From: Sarah Burrow <Sarah.Burrow@arun.gov.uk>
Sent: 01 July 2021 16:07
To: Planning.Responses <Planning.Responses@arun.gov.uk>
Cc: Simon Davis <Simon.Davis@arun.gov.uk>
Subject: RE: Planning Consultation on: BN/62/21/PL

Engineers Comments Regarding Surface Water Drainage

Application No: BN/62/21/PL
Registered: 20th May 2021
Site Address: The Croft Surgery Barnham Road Eastergate PO20 3RP
Grid Reference: 494676 105538
Description of Works: Medical centre with pharmacy retail unit & other ancillary uses together with access onto Barnham Road, associated car parking and other hard and soft landscaping works. This site is in CIL zone 2 (Zero Rated) as other development.

C Drainage Layout Plan

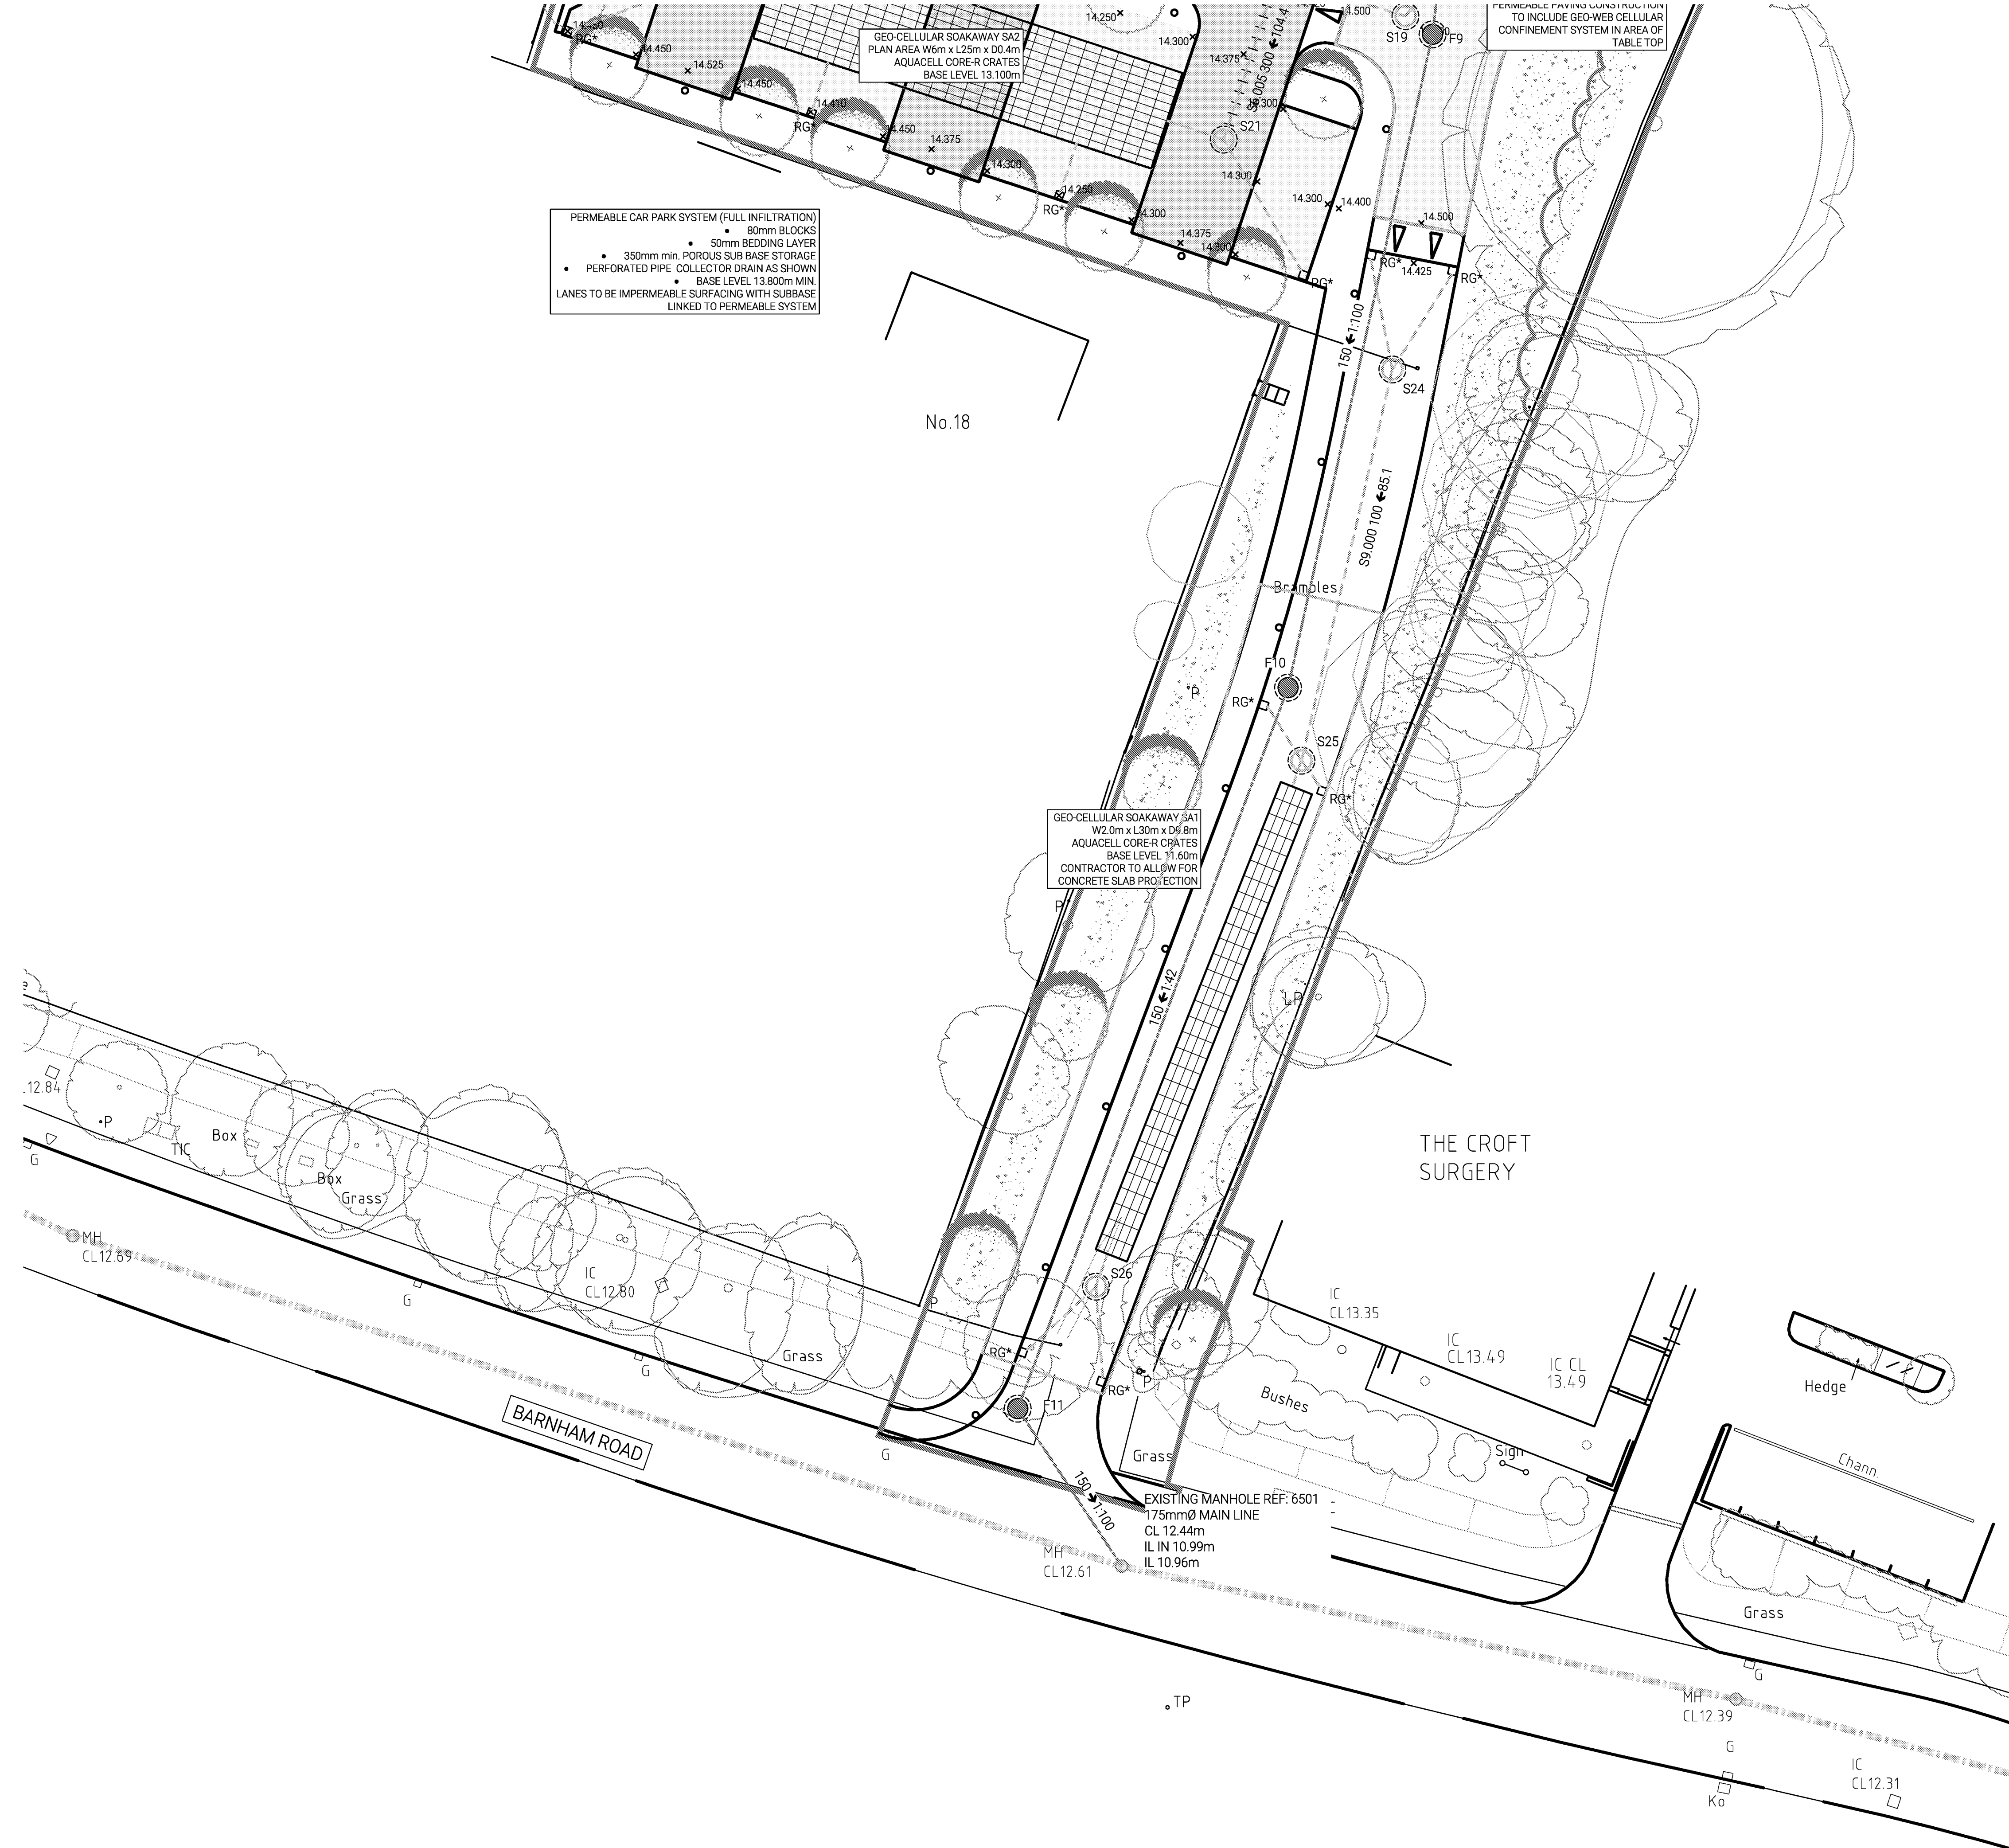
The applicant's Engineers have been in correspondence with Paul Cann, Principal Drainage Engineer. It is understood that he is satisfied with the level of groundwater monitoring and infiltration testing that has been undertaken to support the application. The applicant has submitted a Drainage Strategy Statement which proposes to dispose of surface water via infiltration, initially via permeable paving (which provides treatment and slow rates of infiltration) and then to deeper soakaways in the south parking area and driveway (where infiltration rates are more favourable).

We agree with this general strategy, however, some details may require further detailed design and modification following approval (should you be minded to approve the application). It should be noted that we expect a climate change allowance of 40% to be applied to all storm events to account for climate change for the purposes of calculations (1 in 10 year, 1 in 30 year and 1 in 100 year).

PCENG D2 (modified to remove requirement for groundwater monitoring and infiltration testing)

“Development shall not commence, other than works of site survey and investigation, until full details of the proposed surface water drainage scheme have been submitted to and approved in writing by the Local Planning Authority. The design should follow the hierarchy of preference for different types of surface water drainage disposal systems as set out in Approved Document H of the Building Regulations, and the recommendations of the SuDS Manual produced by CIRIA. No building / No part of the extended building shall be occupied until the complete surface water drainage system serving the property has been implemented in accordance with the agreed details and the details so agreed shall be maintained in good working order in perpetuity.”

“It must also have provision to ensure that there is capacity in the system to contain below ground level the 1 in 100 year storm event plus 40% on stored volumes. Adequate freeboard must be provided between the base of the soakaway structure and the highest recorded annual groundwater level identified in that location. Supplementary guidance notes regarding surface water drainage are located here [Drainage Planning Consultations | Arun District Council](#) on Arun District Councils website. A surface water drainage checklist is available on Arun District Councils website, this should be submitted with a Discharge of Conditions Application.”
